| Reference No:         | <b>2024/62/90869/E</b>                                |
| Site Address:         | 74, Bradbury Street, Ravensthorpe, Dewsbury, WF13 3AT |
| Description:          | Erection of single storey side and rear extensions    |

## HOUSEHOLDER DELEGATED REPORT

PROPOSED SIDE
ELEVATION 1:100

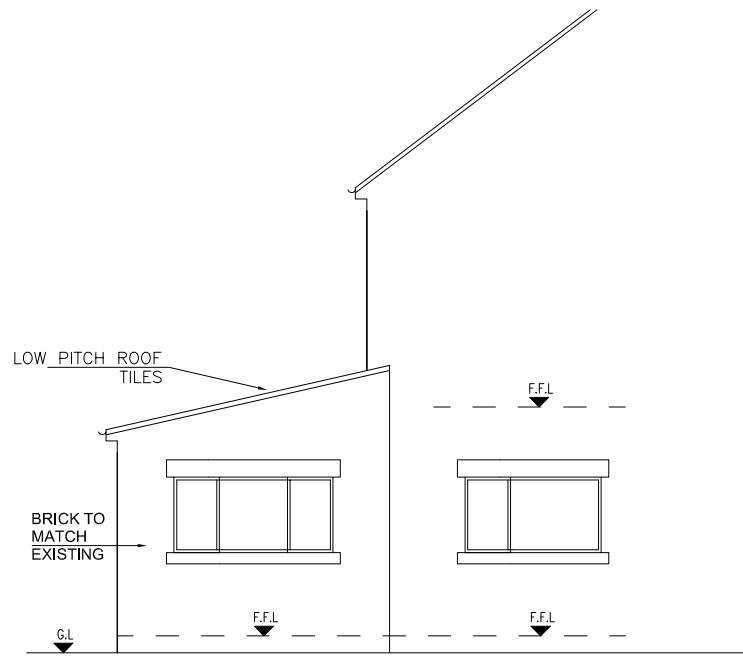
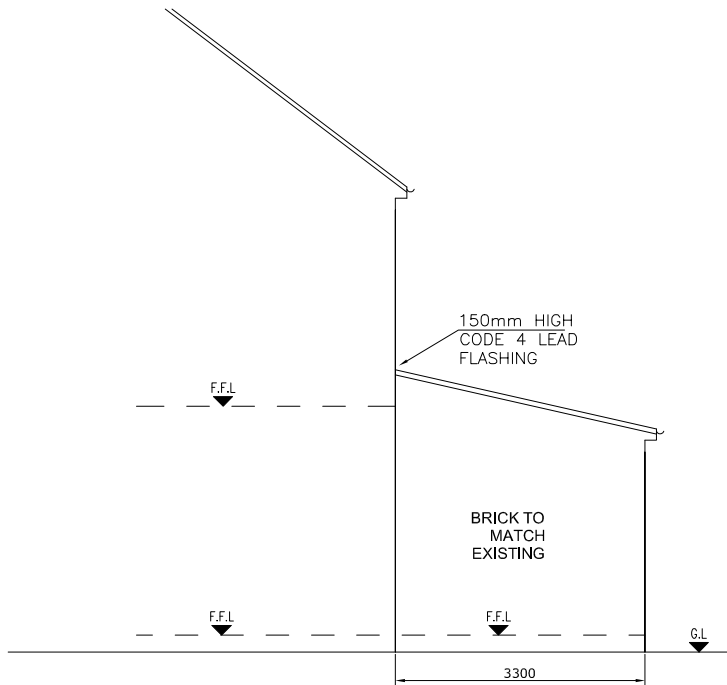
|                                                | <b>Relevant key design principle (KDP) of the SPD, Policy in the Kirklees Local Plan and the NPPF</b>                                                      | <b>Further comments</b>                                                                                                                                                                                                                               | <b>✓ /<br/>X /<br/>N/A</b> |
|------------------------------------------------|------------------------------------------------------------------------------------------------------------------------------------------------------------|-------------------------------------------------------------------------------------------------------------------------------------------------------------------------------------------------------------------------------------------------------|----------------------------|
| Height, scale and massing                      | <ul style="list-style-type: none"> <li>• KDP 1 and 2 of the SPD</li> <li>• Policy LP24 Design (a), (c) and (d) of the KLP</li> </ul>                       | Eaves height of the extension is 2.8m to a maximum height of 3.80m including the pitched roof. Scale of development is                                                                                                                                | ✓                          |

| Roof style                     | <ul style="list-style-type: none"> <li>KDP 1 and 2 of the SPD</li> <li>Policy LP24 Design (a), (c) and (d) of the KLP</li> <li>Chapter 12 of the NPPF</li> </ul> | The chosen pitched roof style is consistent with the pitched roof of the host dwelling.                        | ✓ |

|                                                                      | the Kirklees Local Plan and the NPPF                                                                                                                  |                                                                                                                                                                                                                                                                                                                                                                                                                                                                                                                                                                                                                                                               |   |
|----------------------------------------------------------------------|-------------------------------------------------------------------------------------------------------------------------------------------------------|---------------------------------------------------------------------------------------------------------------------------------------------------------------------------------------------------------------------------------------------------------------------------------------------------------------------------------------------------------------------------------------------------------------------------------------------------------------------------------------------------------------------------------------------------------------------------------------------------------------------------------------------------------------|---|
| Impact on light and outlook of neighbours (to sides, rear and front) | <ul style="list-style-type: none"> <li>• KDP 4, 5, 6 of the SPD</li> <li>• Policy LP24 Design (b)</li> <li>• Chapter 12 of the NPPF</li> </ul>        | <p>The extension will run along the boundary of No. 72, it will have an eaves height of ~2.80m and a projection of ~3.30. There is currently a wall and fencing that serves as a boundary treatment.</p> <p>The extension runs along the boundary, however it is single storey in height. In terms of openings on No 72, there is an opening on the side nearest the application dwelling, however it has been bricked up. The slope of the pitched roof will allow a flow of light to enter the windows and garden.</p> <p>If the openings was to be reused, there would be a sufficient outlook considering the relationship it has with the extension.</p> | ✓ |

PROPOSED GROUND FLOOR PLAN 1:50

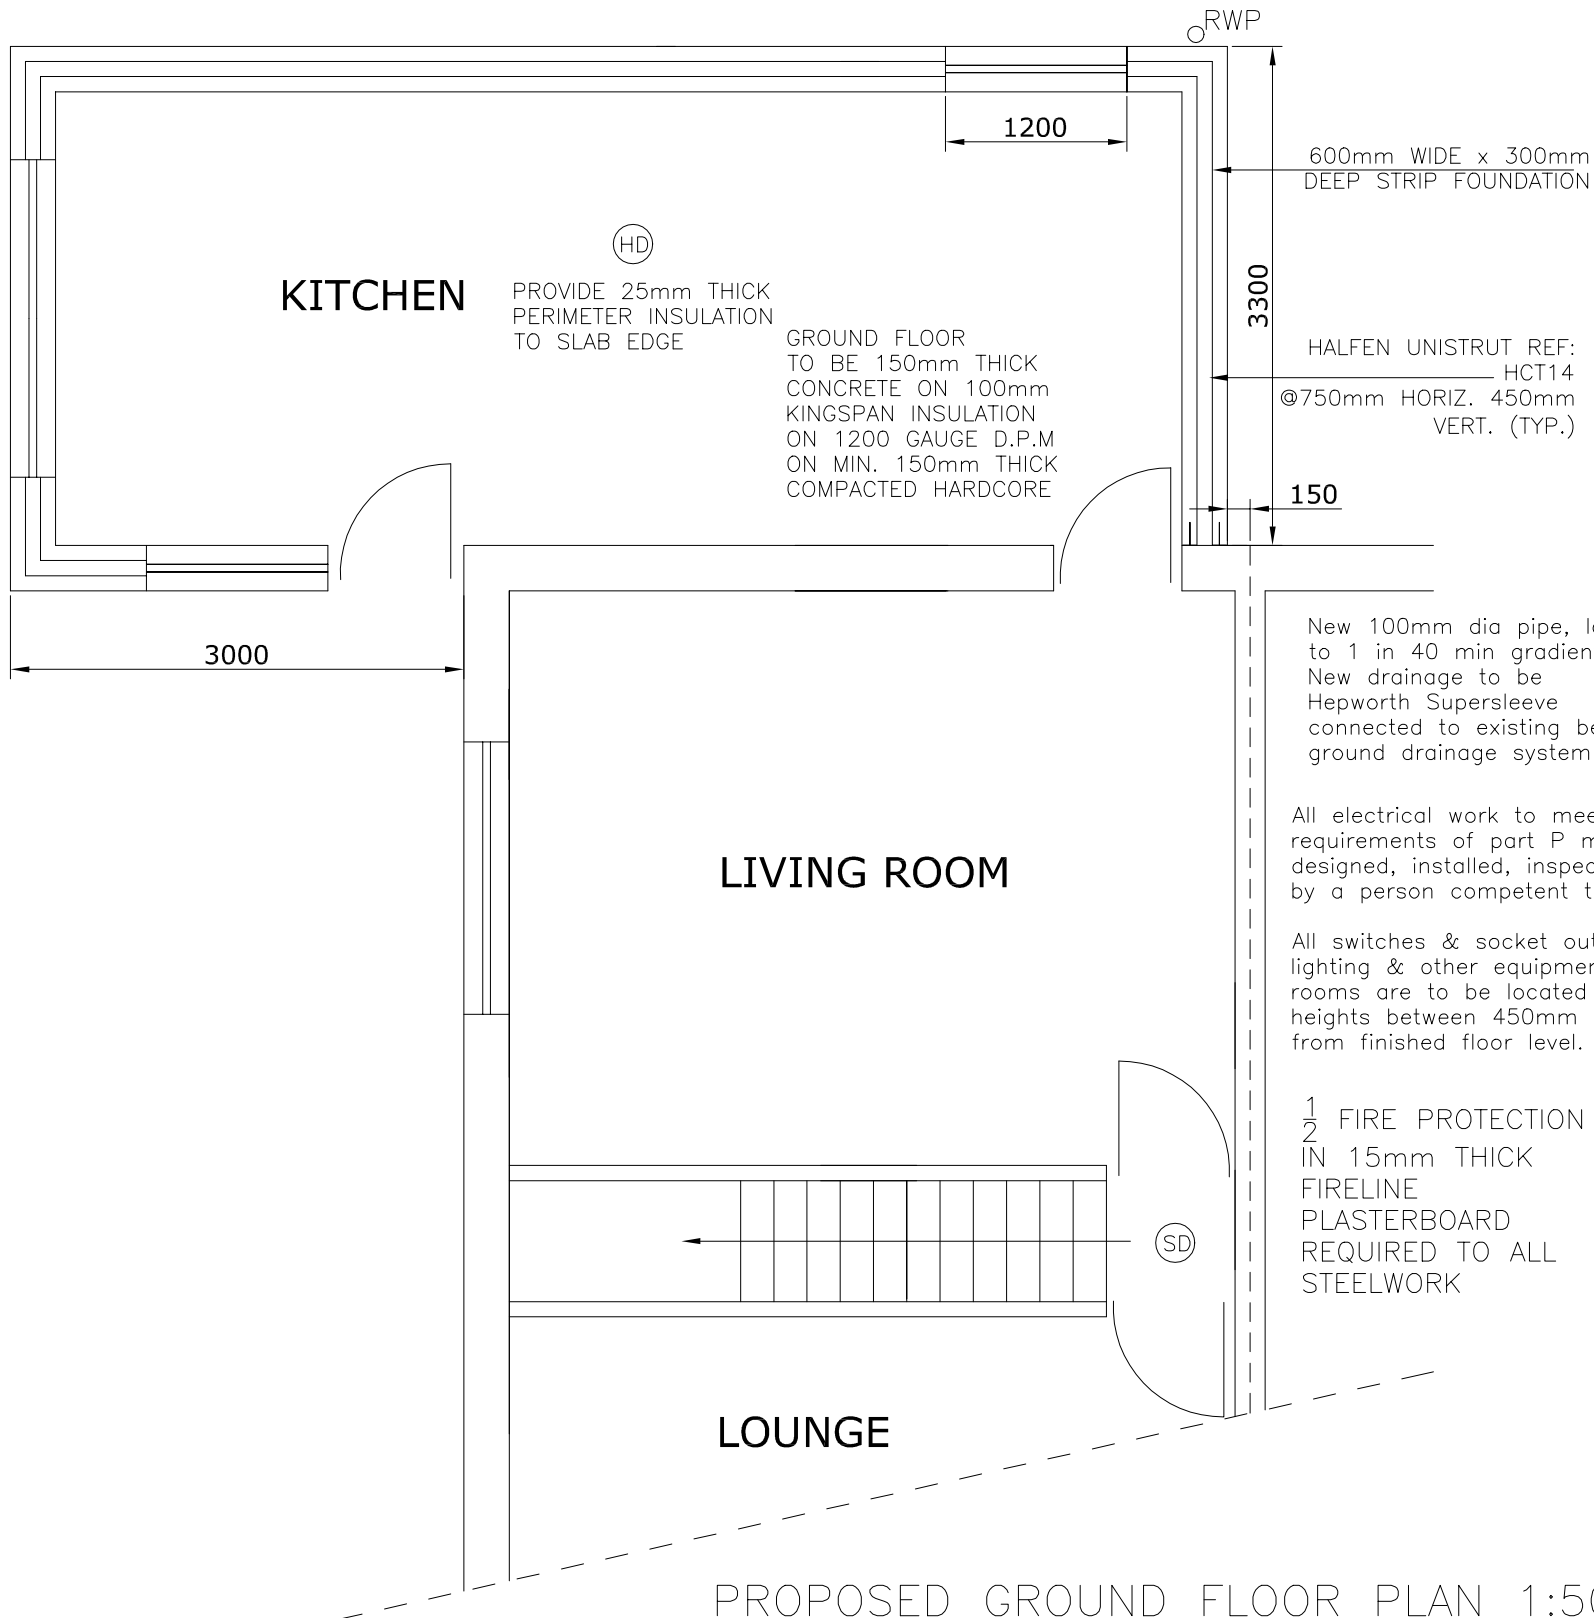
|                                                                    | <b><u>Yes - COMPLY</u></b>                                           | <b><u>No - JUSTIFY</u></b> |
|--------------------------------------------------------------------|----------------------------------------------------------------------|----------------------------|
| Not extend more than two thirds of the width of the original house | Yes – side extension is 3.00m, width of the original house in 5.20m. |                            |

| Not project out more than 3 metres from the rear wall of the original house for semi-detached and terraces houses or by 4 metres for detached properties |                                               | No, the extension projects 3.30m, whilst it is beyond the outlined guidance, the distance is only marginal and would not represent disproportionate additions.                  |
| Where they exceed 3m in length the eaves height should generally not exceed 2.5 meters                                                                   |                                               | No, the eaves of the dwelling are 2.80m in height. Whilst it is beyond the outlined guidance, the distance is only marginal and would not represent disproportionate additions. |
| Retain a gap of at least 1 metre from a property boundary, such as a wall, fence or hedge.                                                               |                                               | No, the extension is single storey, with a sloped pitched roof which mitigates the height.                                                                                      |

|                                                                                        | <b><u>Yes - COMPLY</u></b>                                           | <b><u>No - JUSTIFY</u></b> |
|----------------------------------------------------------------------------------------|----------------------------------------------------------------------|----------------------------|
| Not extend more than two thirds of the width of the original house                     | Yes – side extension is 3.00m, width of the original house in 5.20m. |                            |
